Re: Mariners Row Residential Development, 25-29 Tyng Street and 197-199 York Street, #2004-0048, CBL: 044-C-006

This letter is to confirm that the Portland Planning Authority has reviewed and approved certain revisions to the exterior façade of the Mariners Row building subject to the following condition:

YORK STREET ELEVATION
Scale: 1/4" = 1'-0"

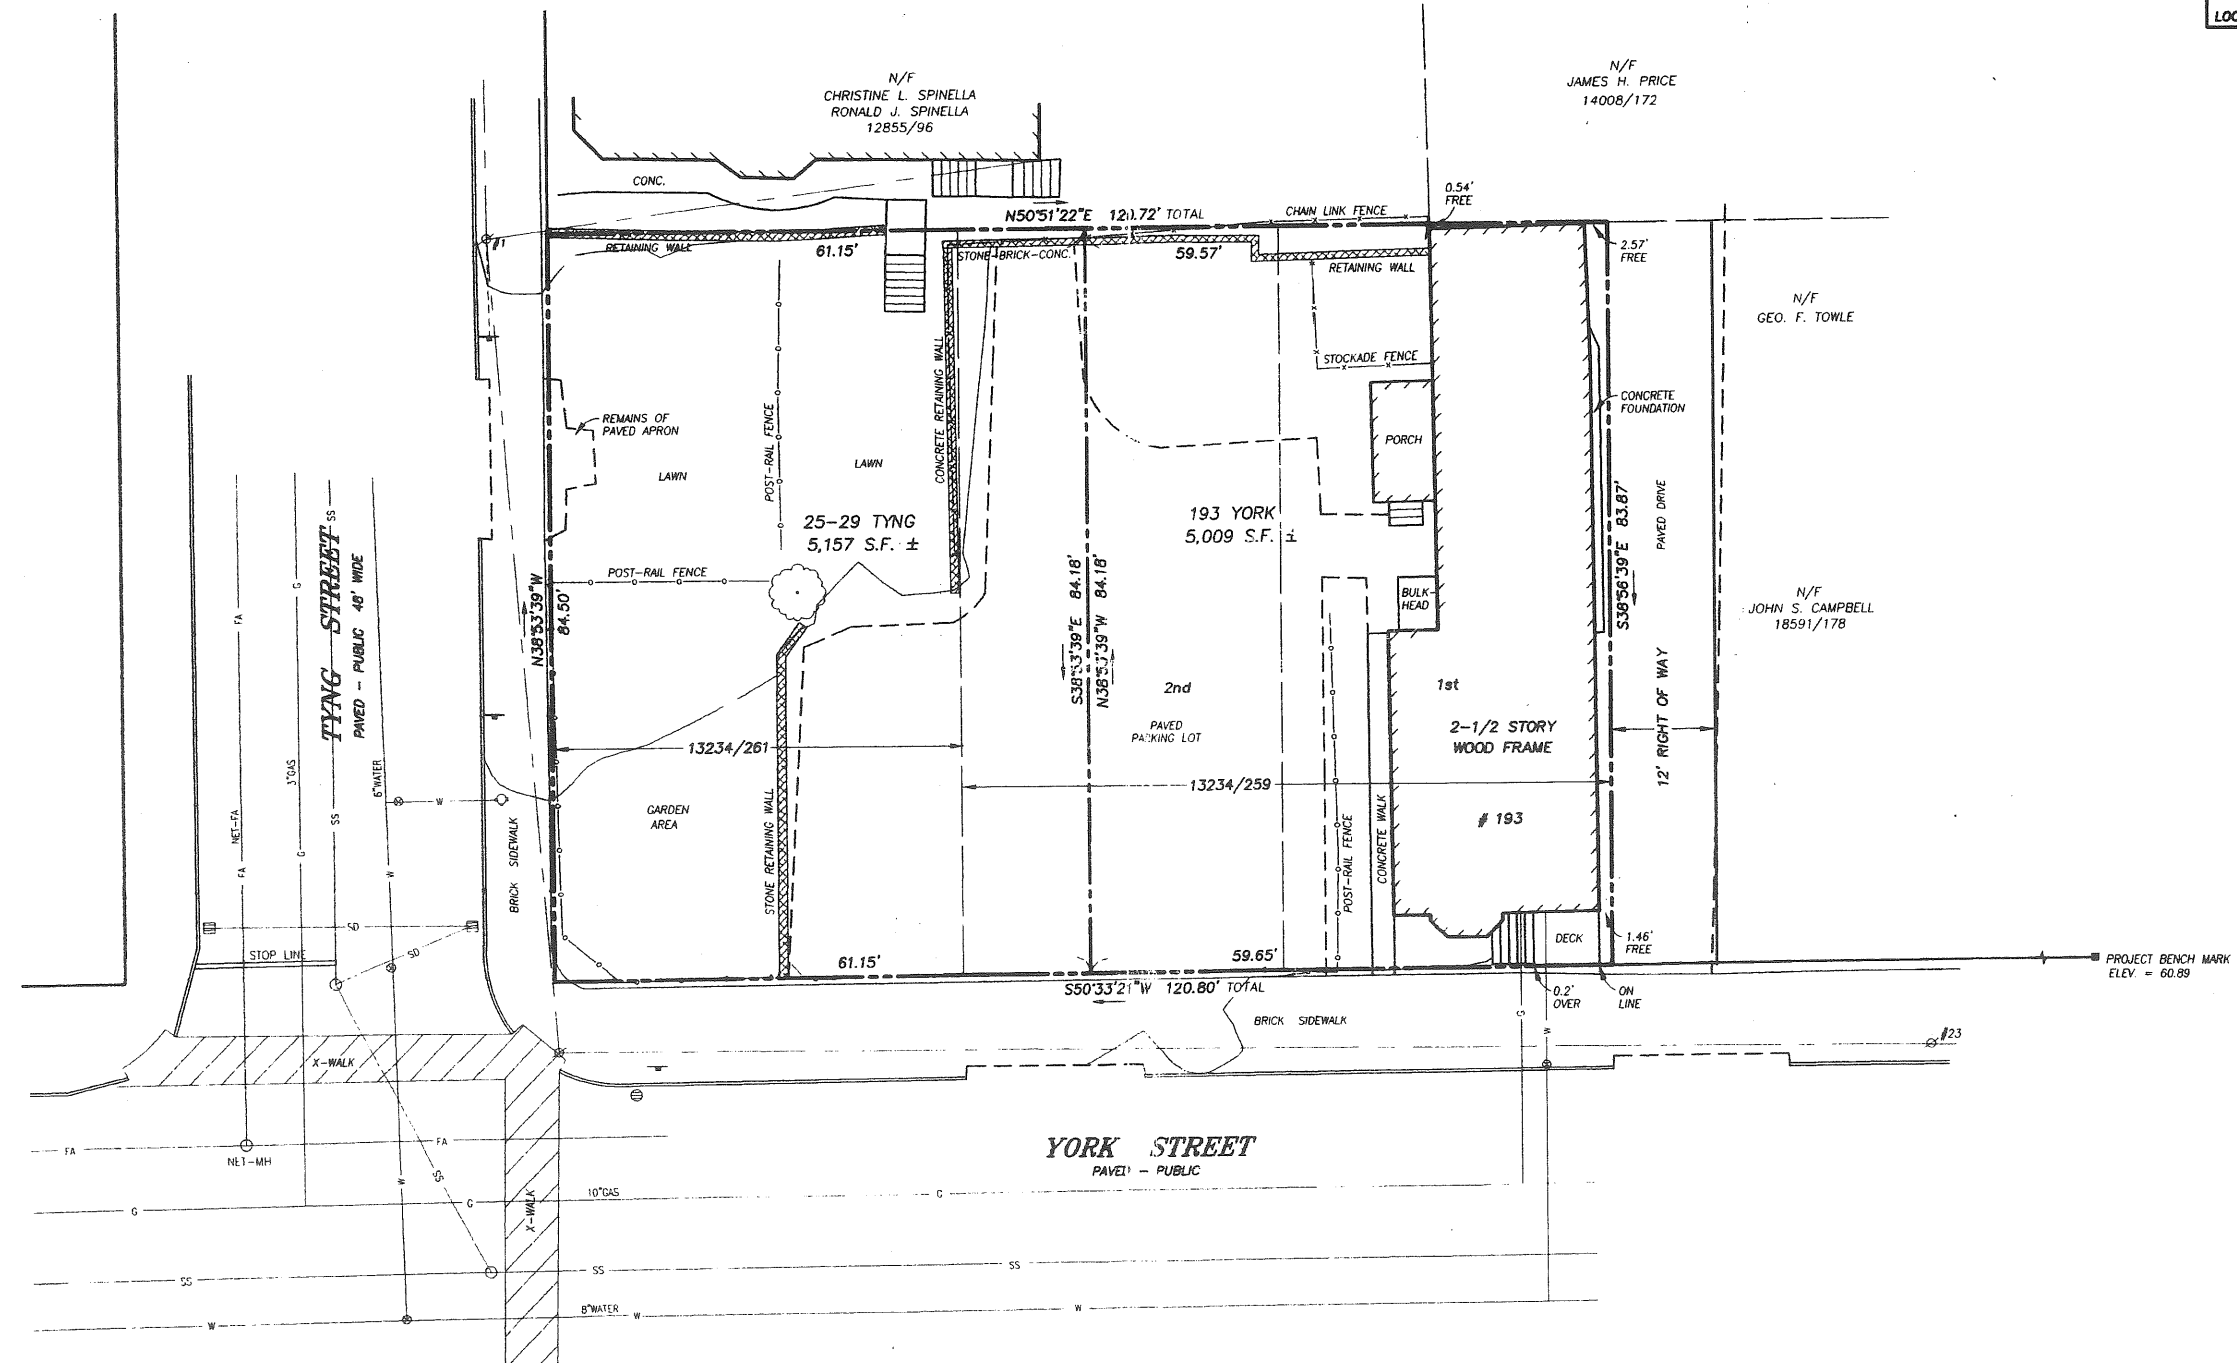
- i. That the windows within the bay along York Street shall be 6 over 6 or 4 over 4, unless otherwise approved in writing by the Portland Planning Authority.

This approval assumes the trim along the York Street façade is consistent with the trim on the remainder of the building.
